CITY OF PORTLAND, MAINE

**BUILDING INSPECTION
PERMIT**

is permission to Build New 3 bedroom 2.5 bath single family home w/2 car garage

ONE AND TWO FAMILY	PLAN REVIEW	CHECKLIST		
Soil type/Presumptive Load Value (Table R401.4.1)				
Component	Submitted Plan	Findings	Revisions	Date
STRUCTURAL Footing Dimensions/Depth (Table R403.1 & R403.1(1), (Section R403.1 & R403.1.4.1)	16" x 10" garage 4' 20" x 10" house 7'9" 8" wall			
Foundation Drainage, Fabric, Damp proofing (Section R405 & R406)	4" perf Pipe, filter, bituminous			
Ventilation/Access (Section R408.1 & R408.3) Crawls Space ONLY	Full Basement			
Anchor Bolts/Straps, spacing (Section R403.1.6)	1/2" bolt 12" corners 6' OC.			
Lally Column Type (Section R407)		3 1/2" conc. filled		
Girder & Header Spans (Table R 502.5(2))	7'-4" shown Max @ 28' = 6'3" Max @ 30' = 6'1"	6/24/10 Max spacing 5'5"	OK	
Built-Up Wood Center Girder Dimension/Type	? →	6/18 3-2x12	OK	
Sill/Band Joist Type & Dimensions	2x6 PT 2x10 Rim			
First Floor Joist Species Dimensions and Spacing (Table R502.3.1(1) & Table R502.3.1(2))	2x10 - 16" OC @ 14'-6" " 12" OC @ 16'-2"

SCALE: 1/4" = 1'-0"
1ST FLOOR PLAN

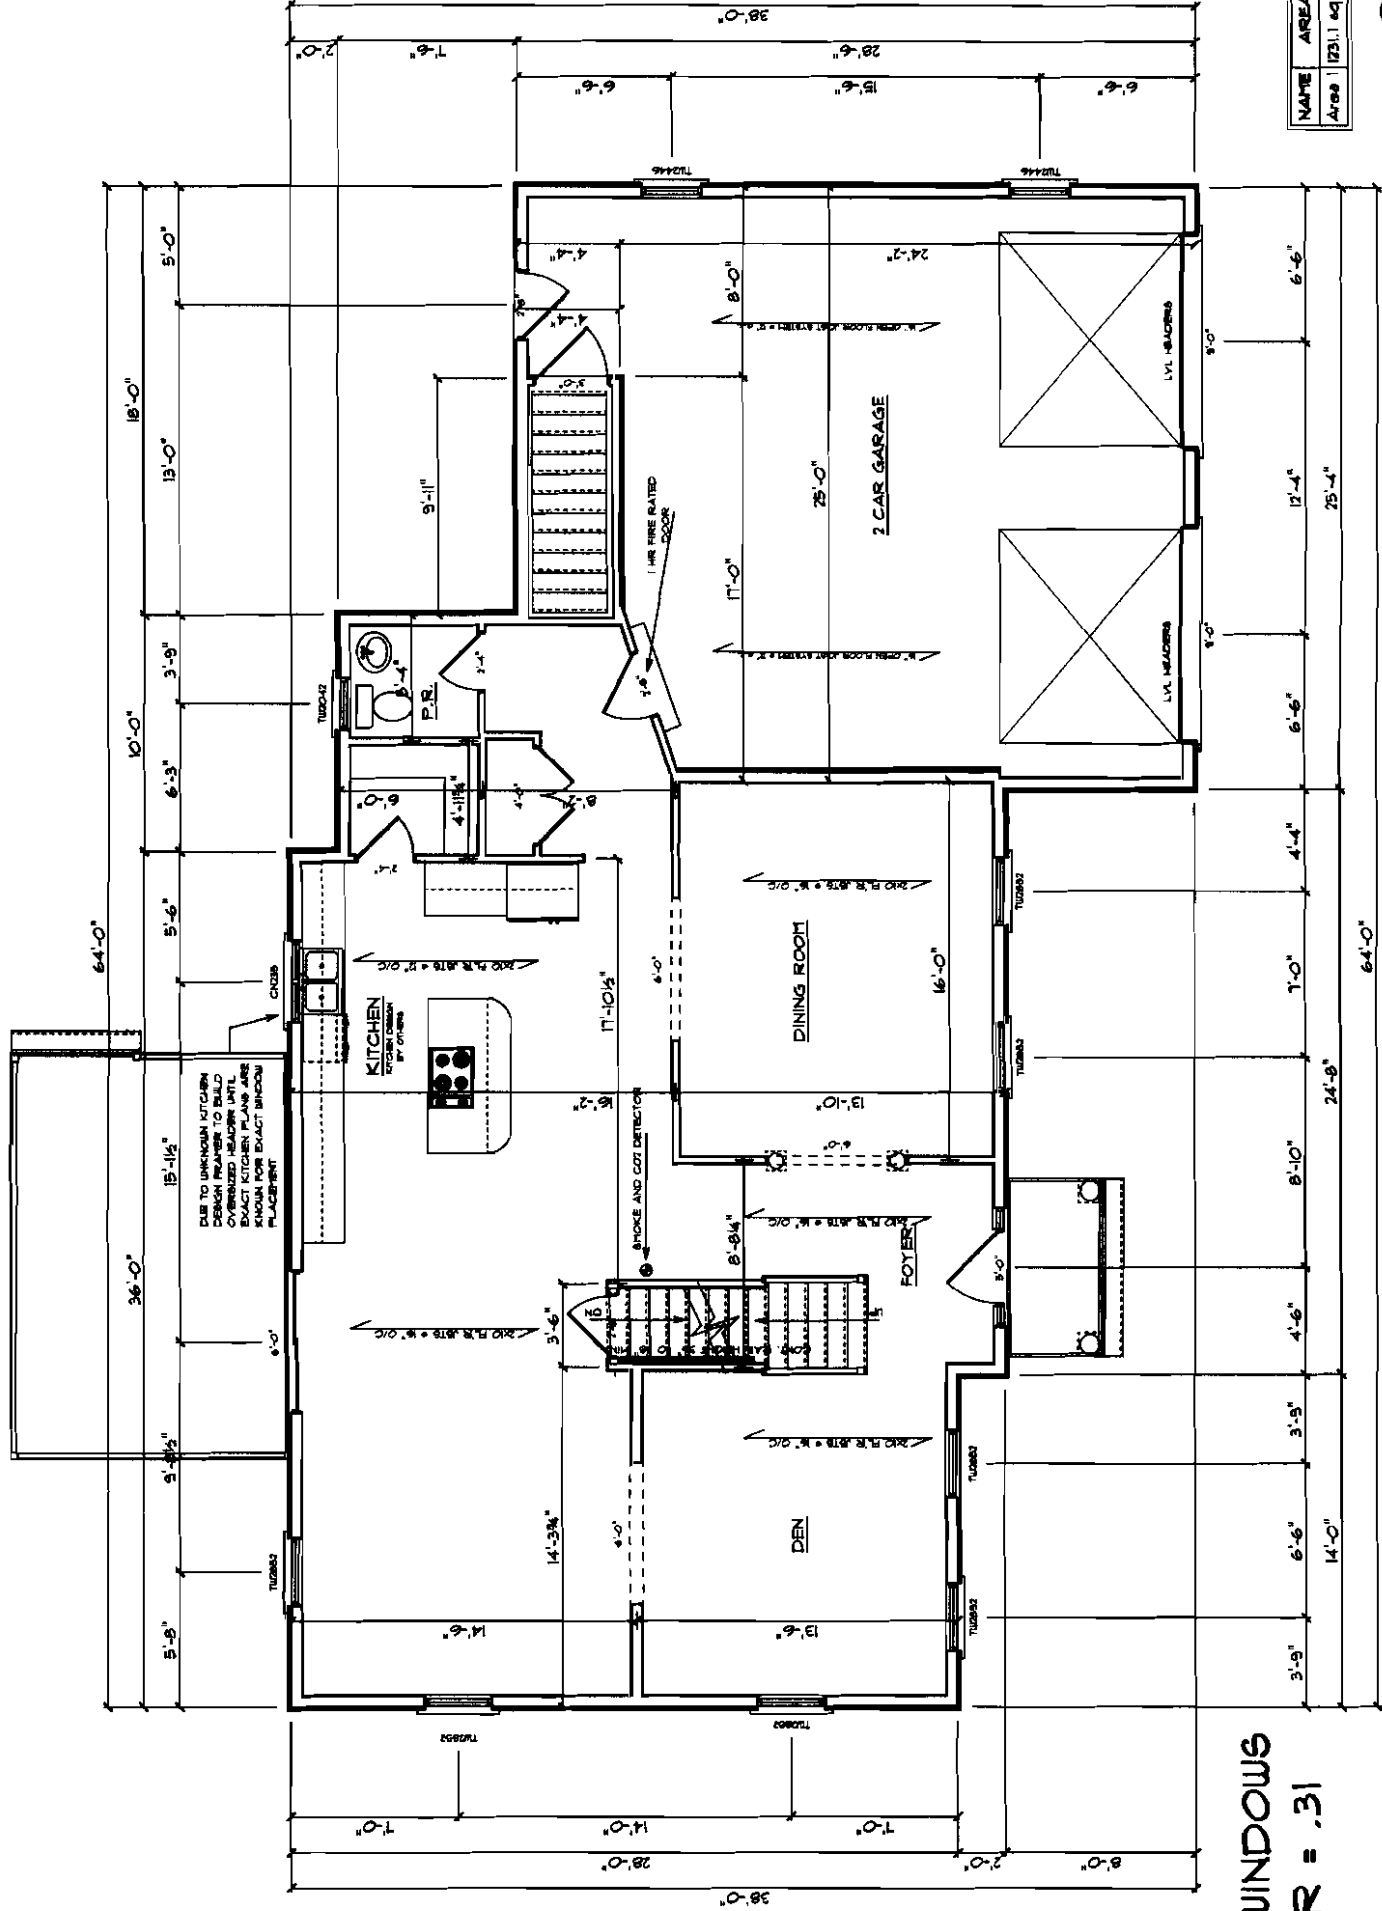
Type of Heating System	?	6/18 FFW Power vent	8
Means of Egress (Sec R311 & R312)			
Basement	yes stairs into garage not habitable		
Number of Stairways	2		
Interior	2		
Exterior	—		
Treads and Risers (Section R311.5.3)	R-7 3/4" max 10" min tread		
Width (Section R311.5.1)	3'		
Headroom (Section R311.5.2)	? Main = 36"-38"	6/18 6'-8" OK	9
Guardrails and Handrails (Section R312 & R311.5.6 – R311.5.6.3)			
Smoke Detectors (Section R313)	smokes & CO OK		
Location and type/Interconnected	Also in garage →	per Rob T. Elect will delete	10
Draftstopping (Section R502.12) and Fireblocking (Section R602.8)	N/A		
Dwelling Unit Separation (Section R317) and IBC – 2003 (Section 1207)			
Deck Construction (Section R502.2.1)	11.5 x 17 need Footing layout 2x10 @ 16" OC ? Beam	per Rob T. 3-2x10 beam 3 sono tubes max span 9' OK	11

CROSS SECTION A-A
 SCALE: 1/4" = 1'-0"

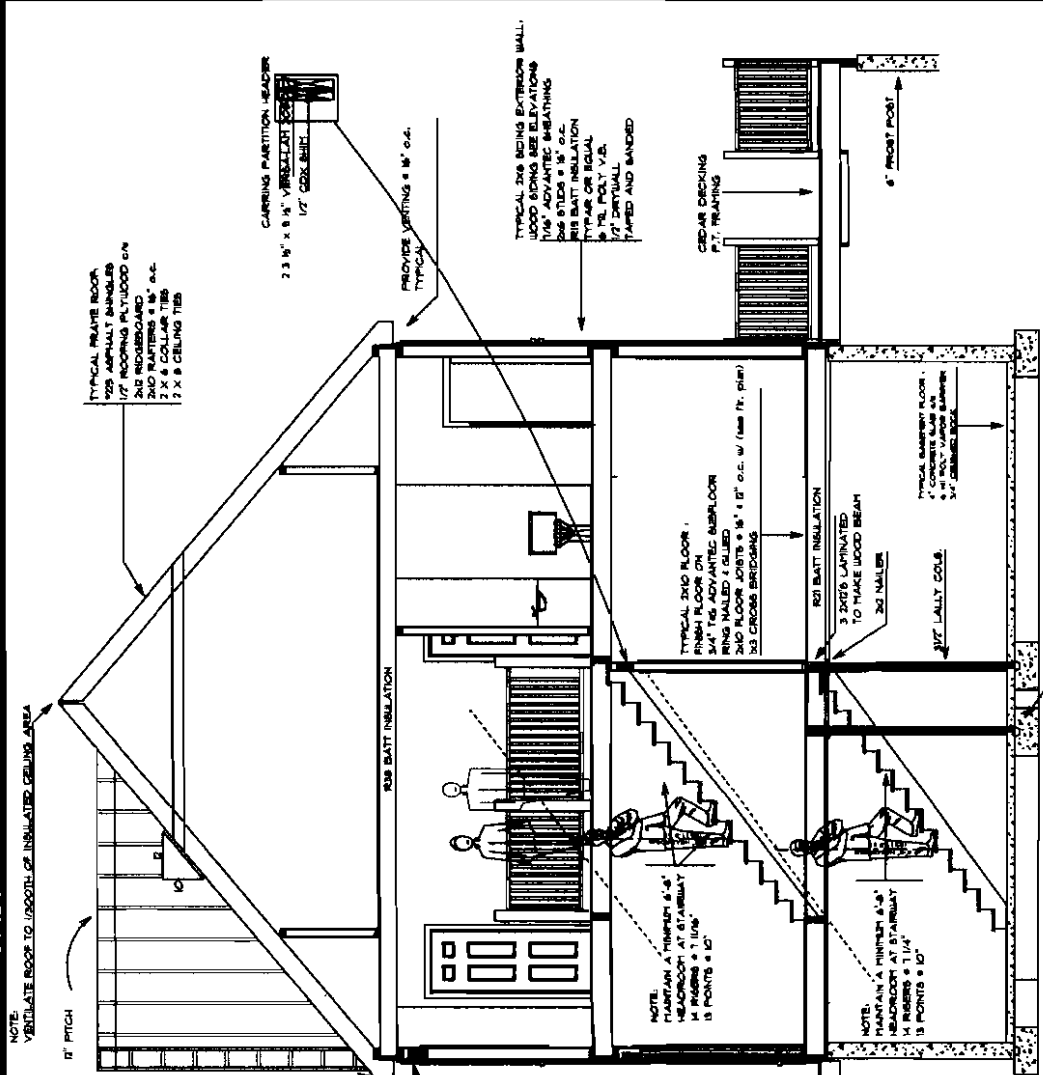
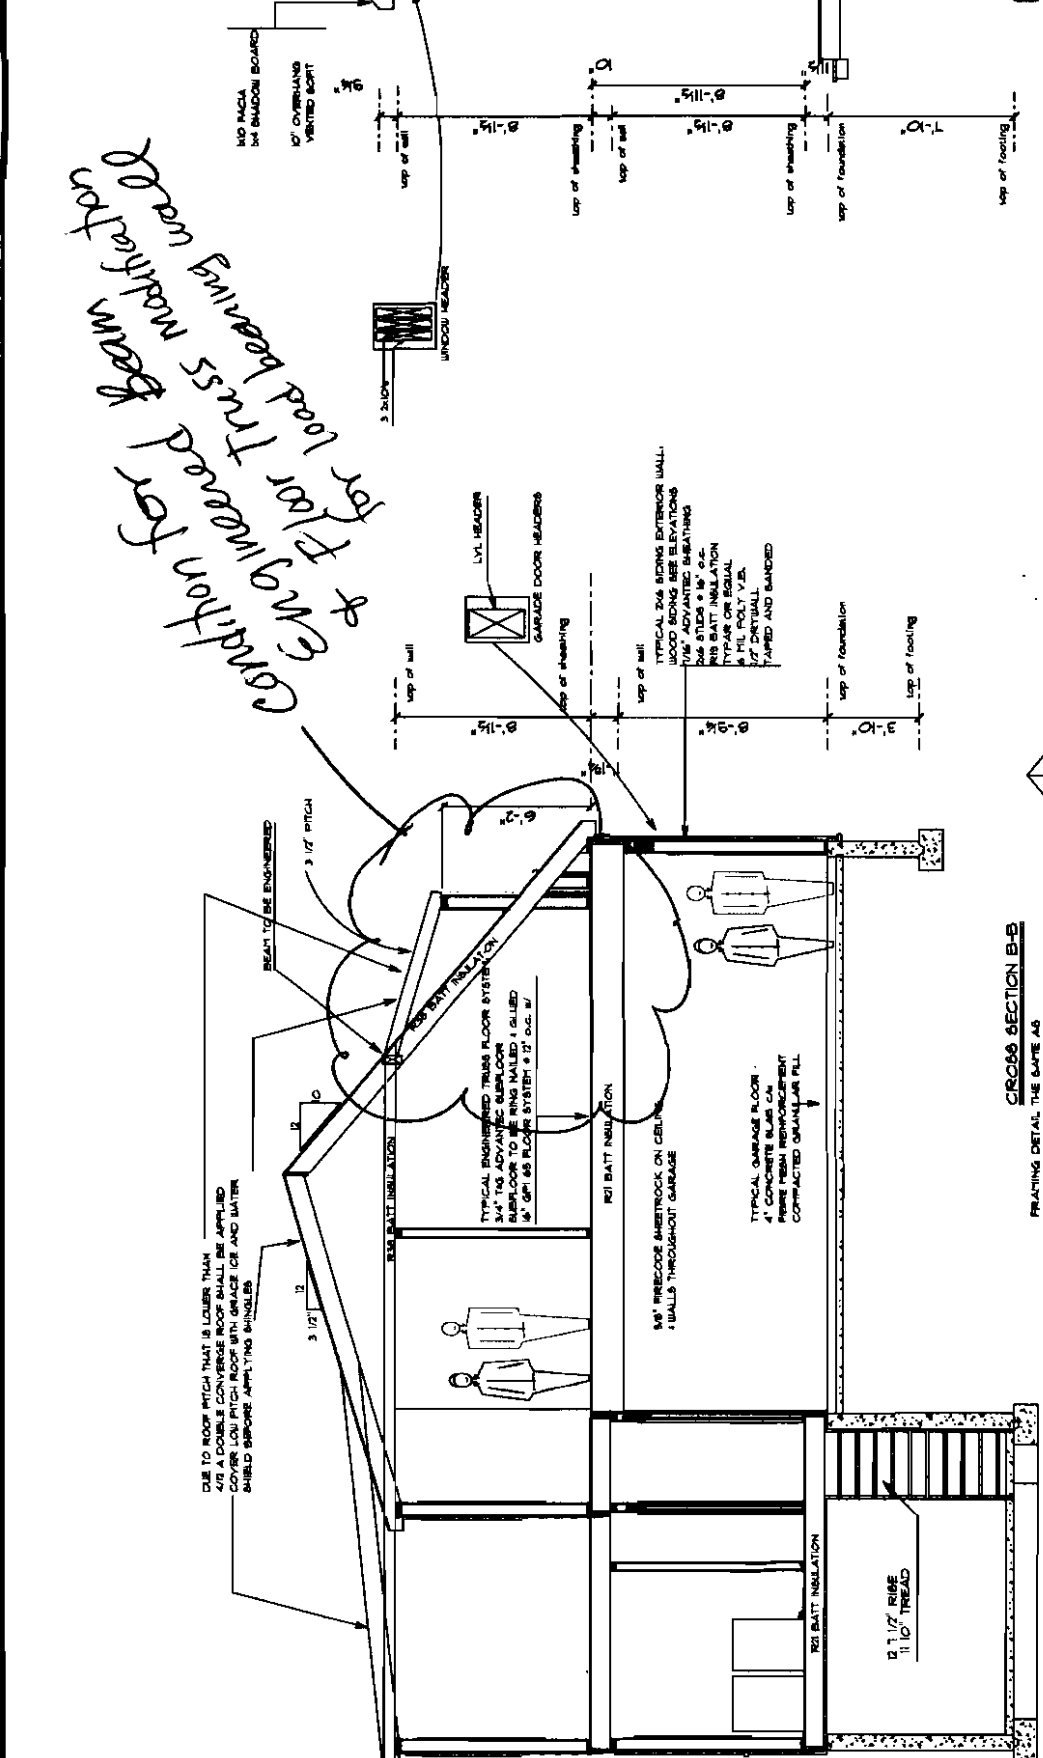
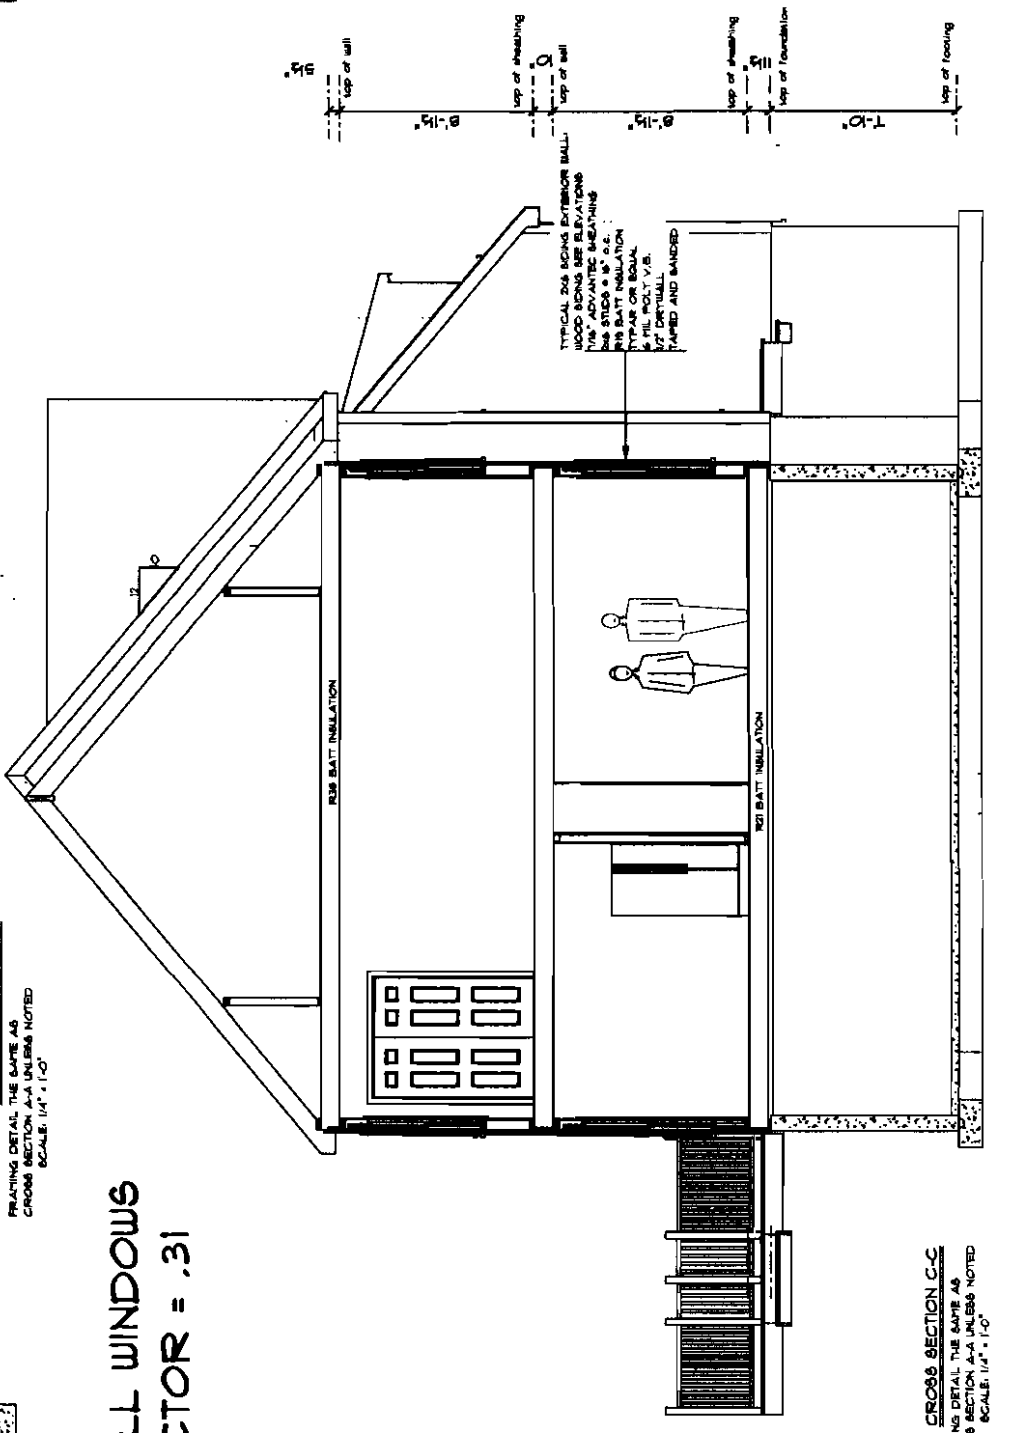
Second Floor Joist Species Dimensions and Spacing (Table R502.3.1(1) & Table R502.3.1(2))	Garage 13" OFJ 12" OC @ 25' House 2x10 @ 16" & 12" OC.	perpendicular to rafters Need double @ load wall/beam 6/24/10 - changed direction of floor trusses max 16'11" condition for spec studs	OK	
Attic or additional Floor Joist Species Dimensions and Spacing (Table R802.4(1) and R802.4(2))	2x8 @ 16" OC. & (2x6 @ 16" OC @ 26" Garage	scales 18'6" will rein force w/ beam or Angled ties	OK

No Sections A-A, B-B, CC 6/18 submitted
